DEPARTMENT OF PARKS AND COMMUNITY SERVICES

September 26, 2023

Subject: Haven Valley Final Plat – Preliminary Comments (SF-23-023)

HAVEN VALLEY SUBDIVISION

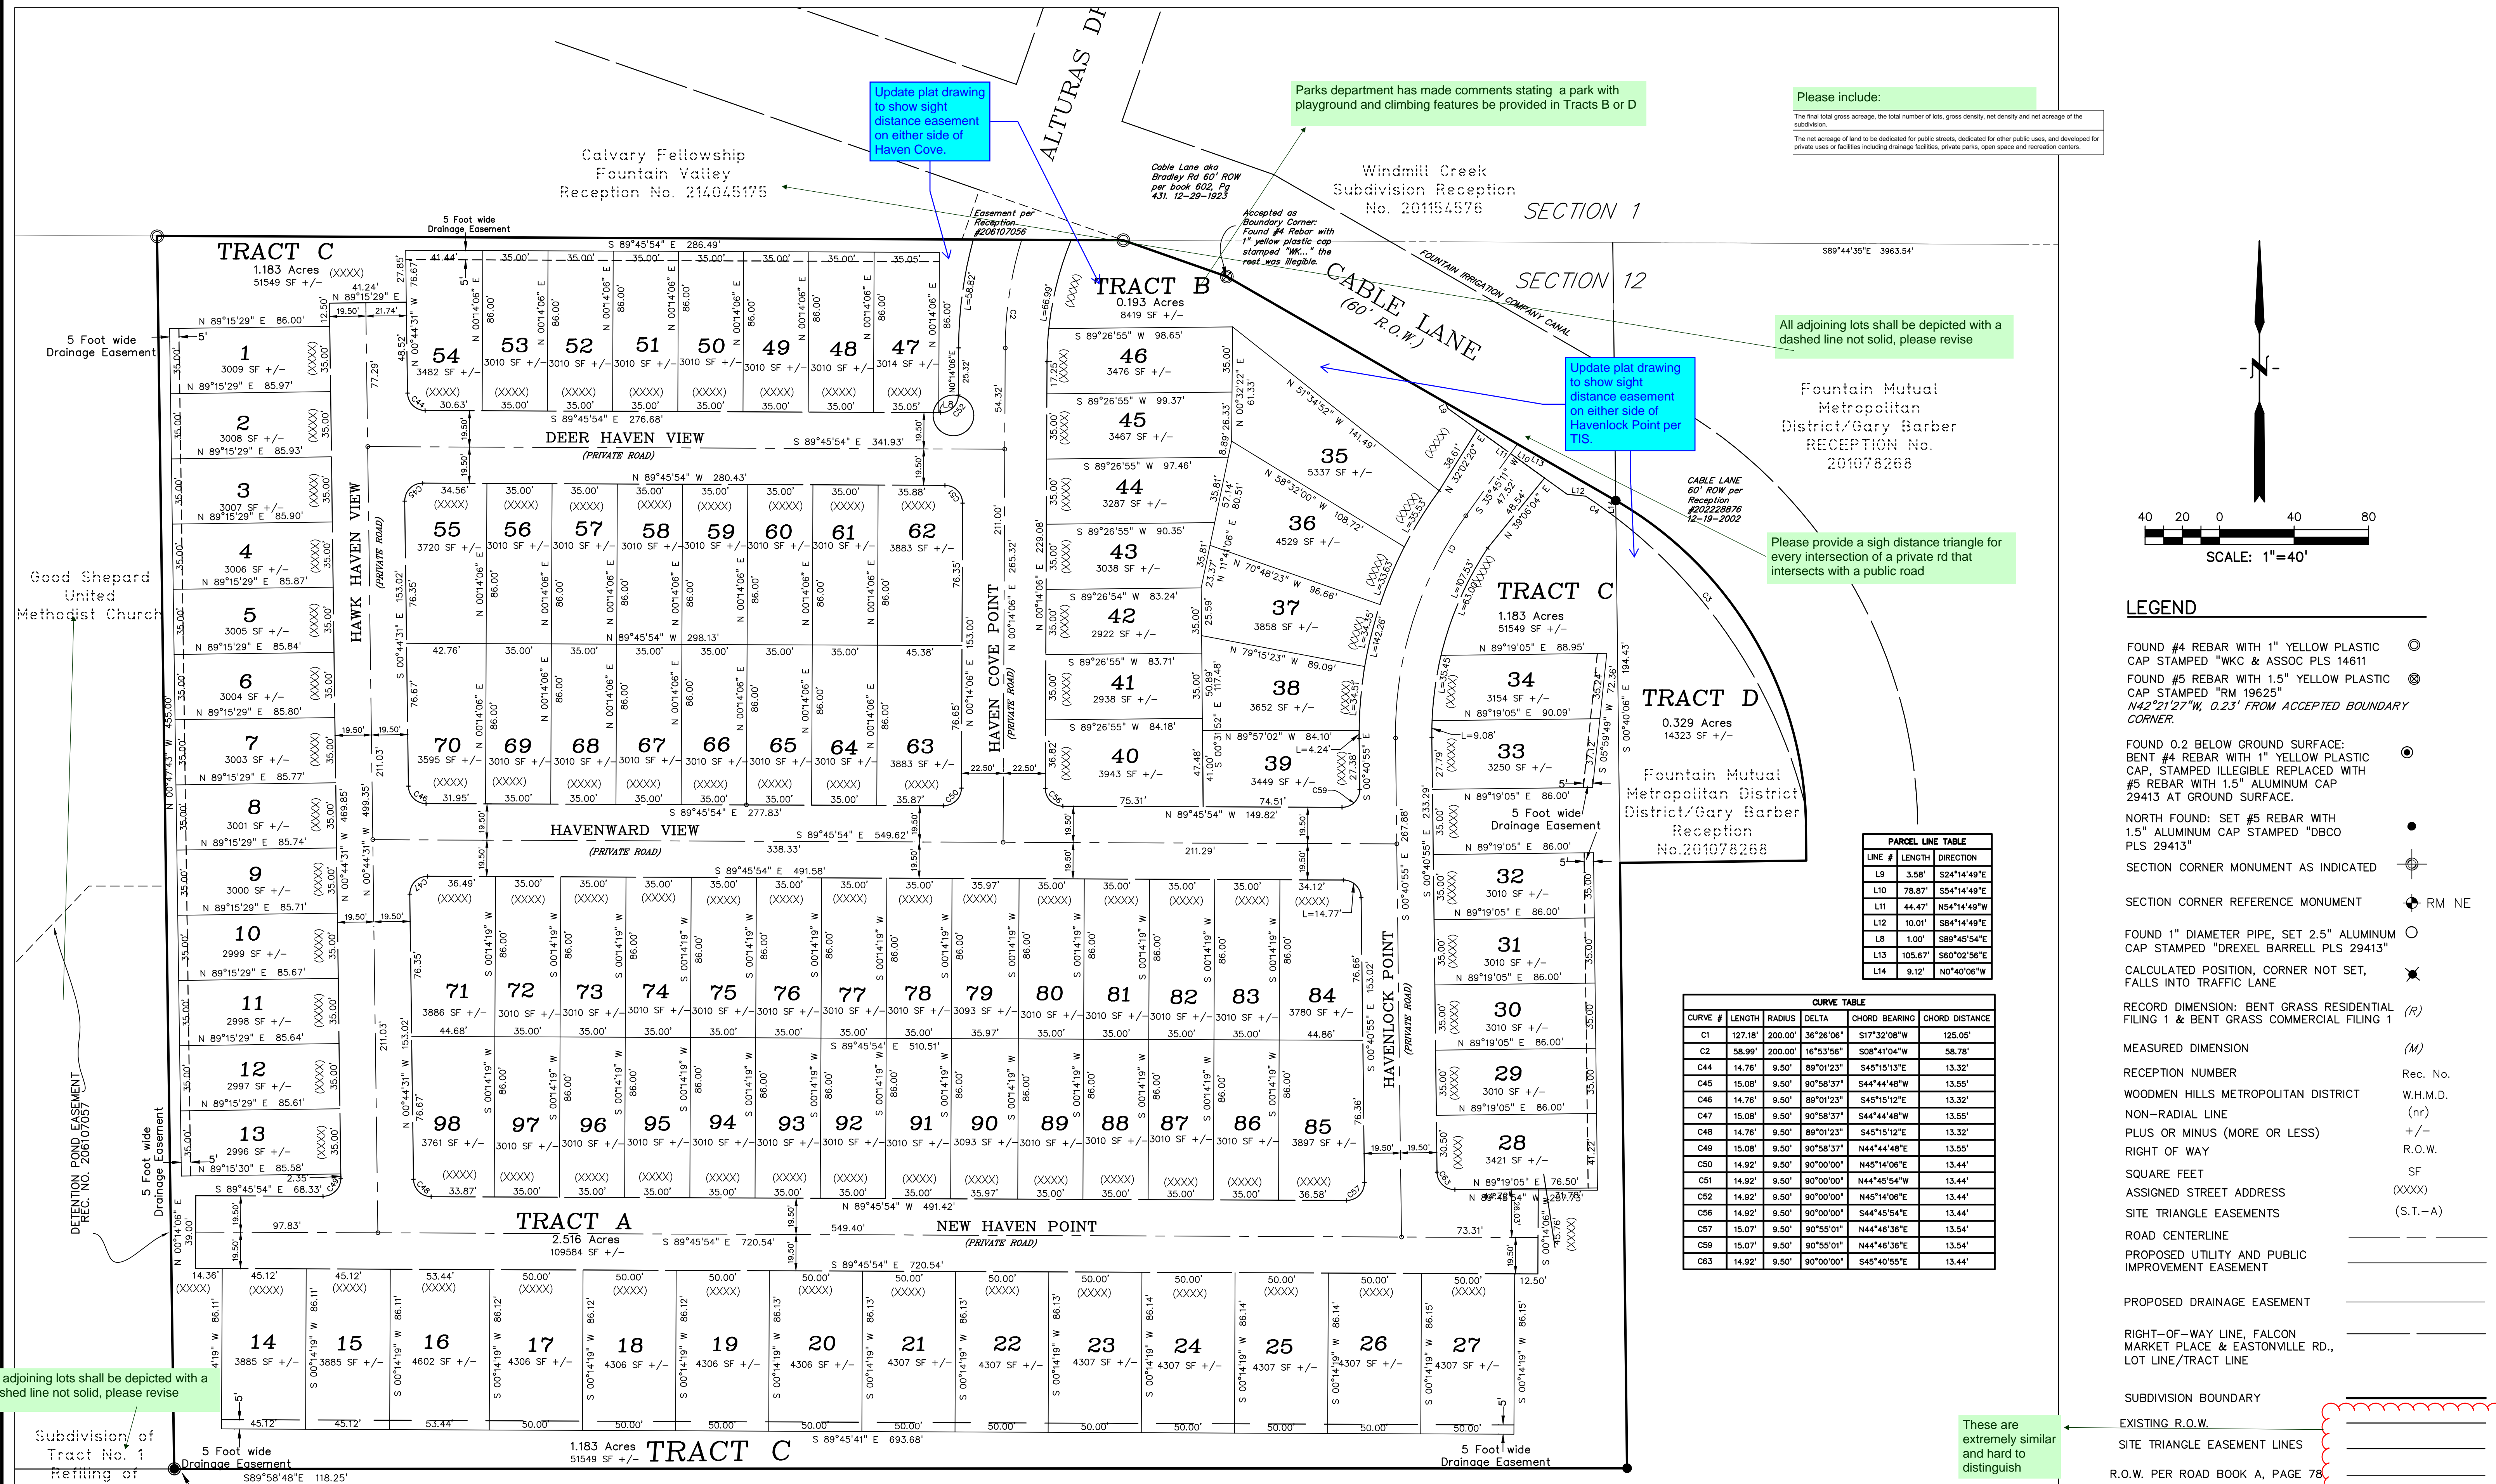
Due to the lack of nearby multi-generational active recreational opportunities for the residents of Haven Valley, staff strongly encourages the applicant to develop a small pocket park with a playground, climbing features, or other active-use amenities in Tracts C and D, as the nearby pocket park does not offer these types of amenities beyond a picnic pavilion with tables and benches.
